REQUEST

Current Zoning: ML-1 (Manufacturing & Logistics 1), ML-2 (Manufacturing & Logistics 2), and N1-B (Neighborhood 1-B)
Proposed Zoning: I-2 (CD) (General Industrial, Conditional)

Approximately 5.86 acres located on the east side of China Grove Church Road, south of Westinghouse Boulevard, and north of Blu Rail Way.

**SITE PLAN**

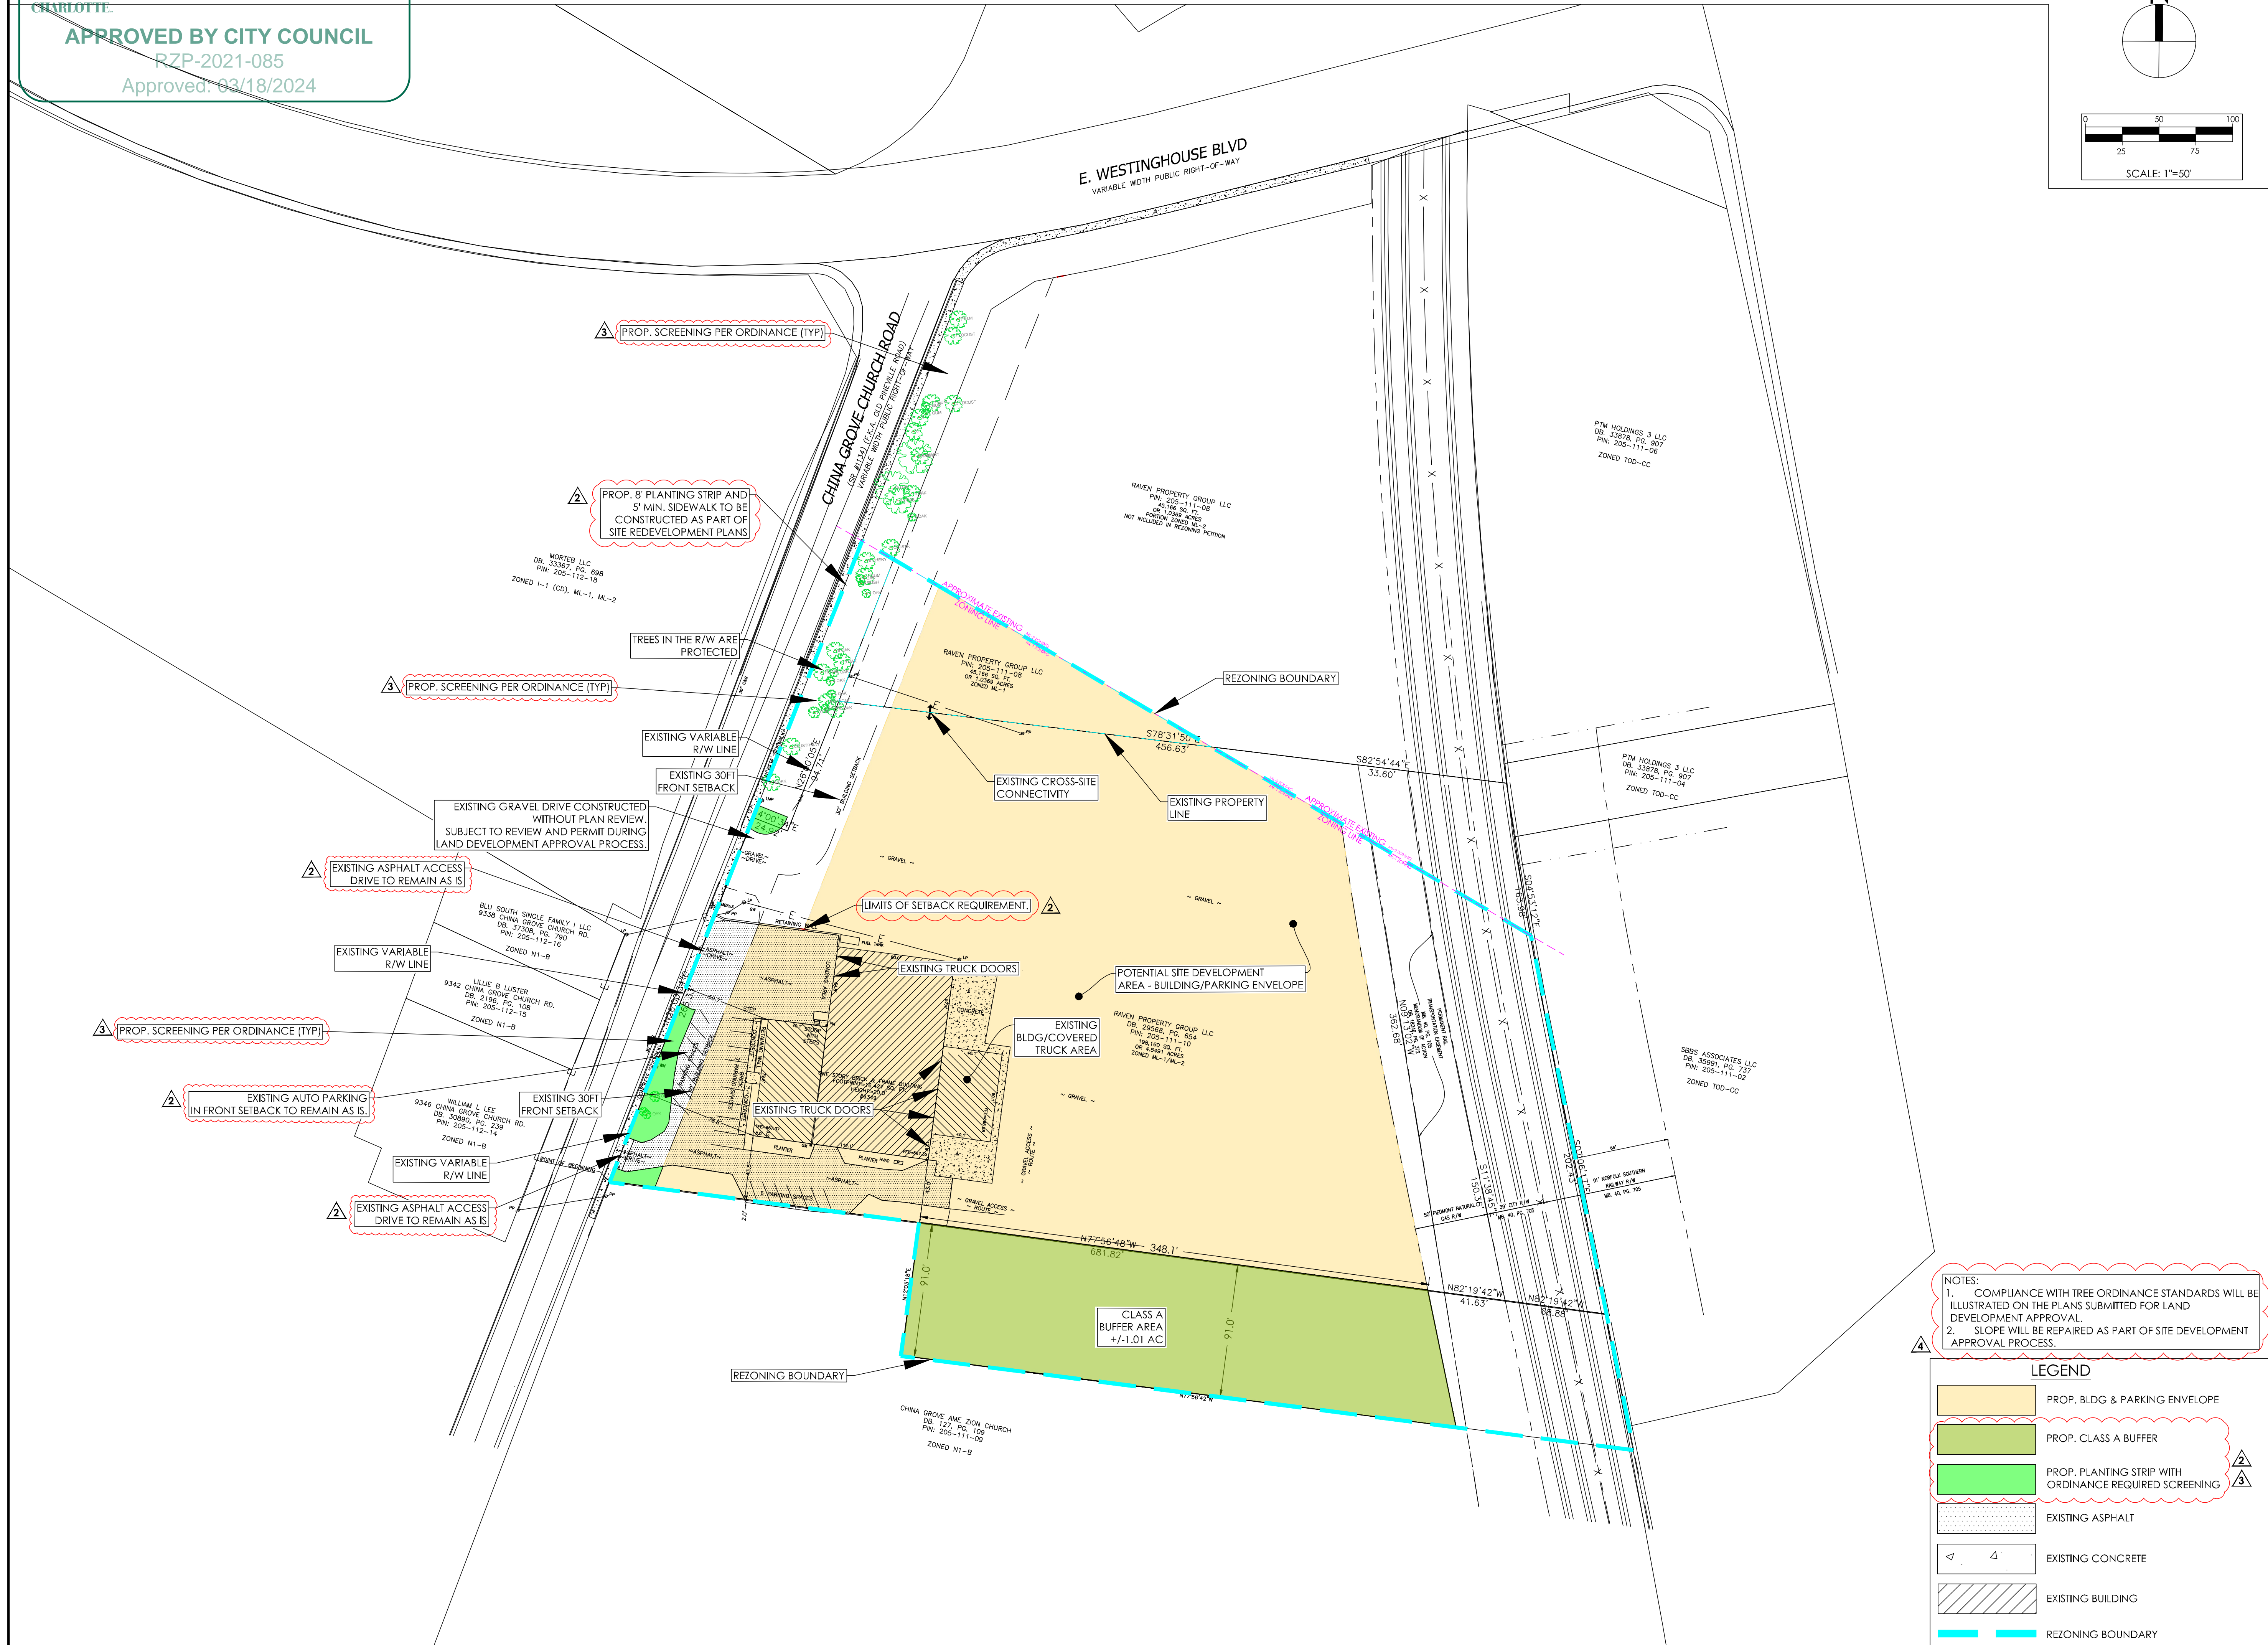
1. Provide a tree survey identifying all trees of eight-inch DBH or greater and all planted trees of two inch caliper or greater and six feet in height that grow partially or wholly within public street right-of-way. The survey shall also identify all trees of eight-inch dbh or greater within the tree protection zone.
2. Remove parking area and driveway in the southwestern corner of the site and plant buffer.
3. Illustrate ordinance required screening along China Grove Church Road on the site plan.
